Submission Form

Epping to Thornleigh Third Track Proposal. Application number SSI 5132.

Figure 5.5 Artist's impression of new elevated concourse at Cheltenham Station looking south from The Crescent (indicated circle)

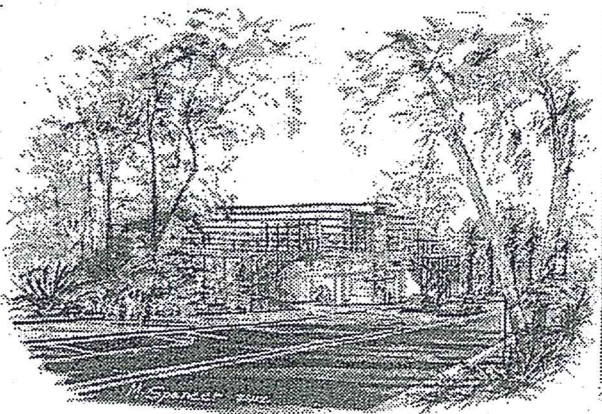
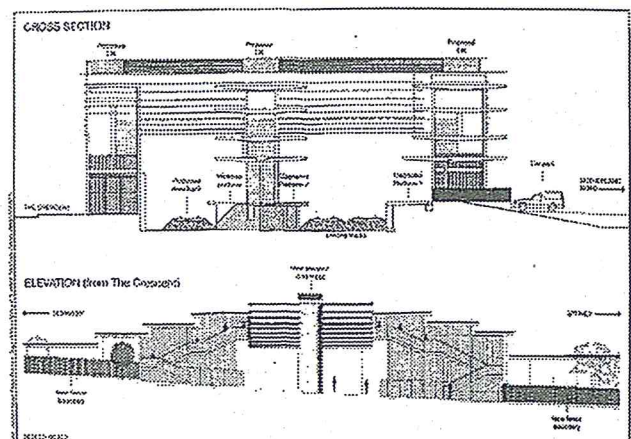
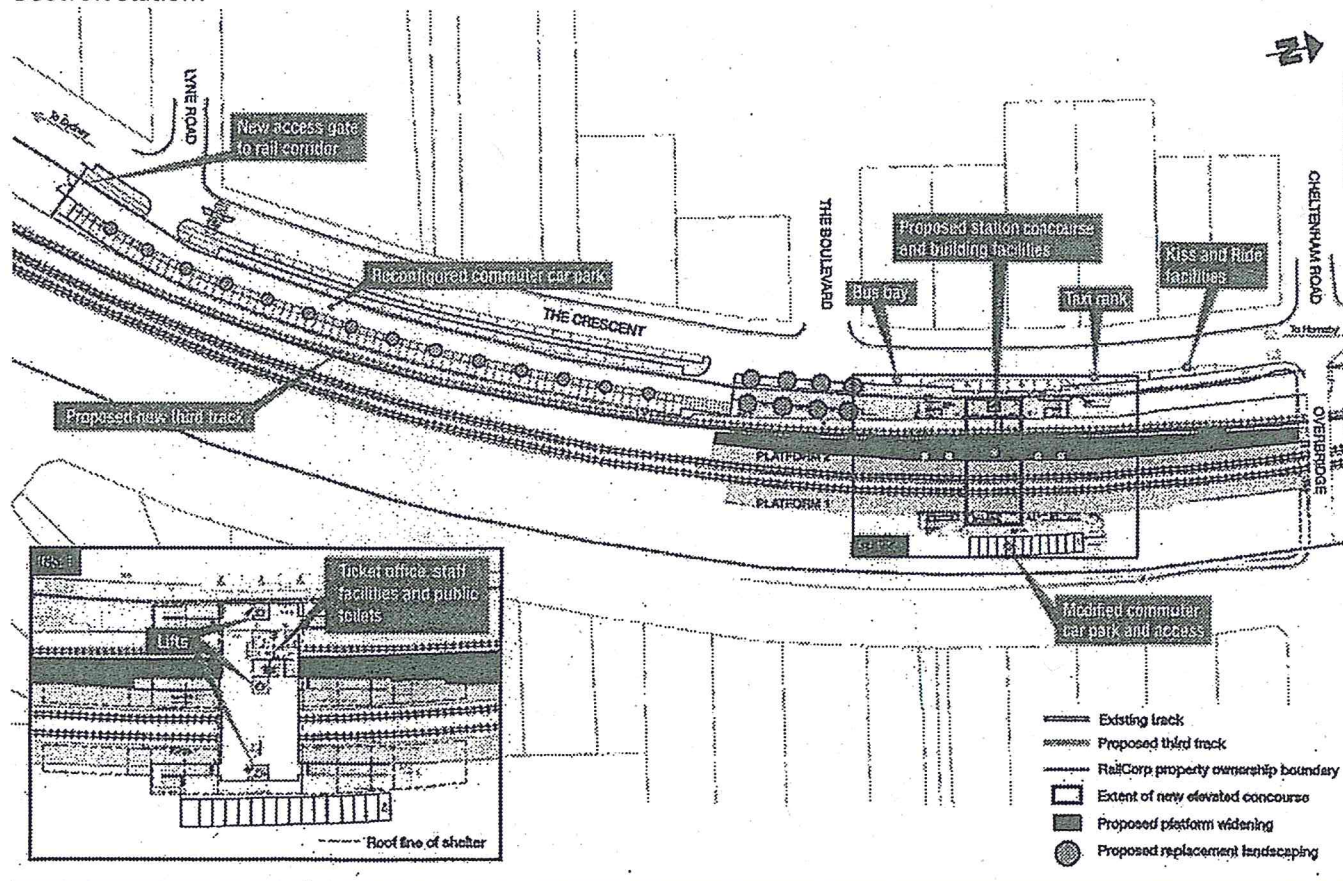
- The proposed redevelopment of Cheltenham Station shows no regard for the HCA. The visual impact of the proposed 13m high glass and steel concourse is totally unacceptable in this HCA.
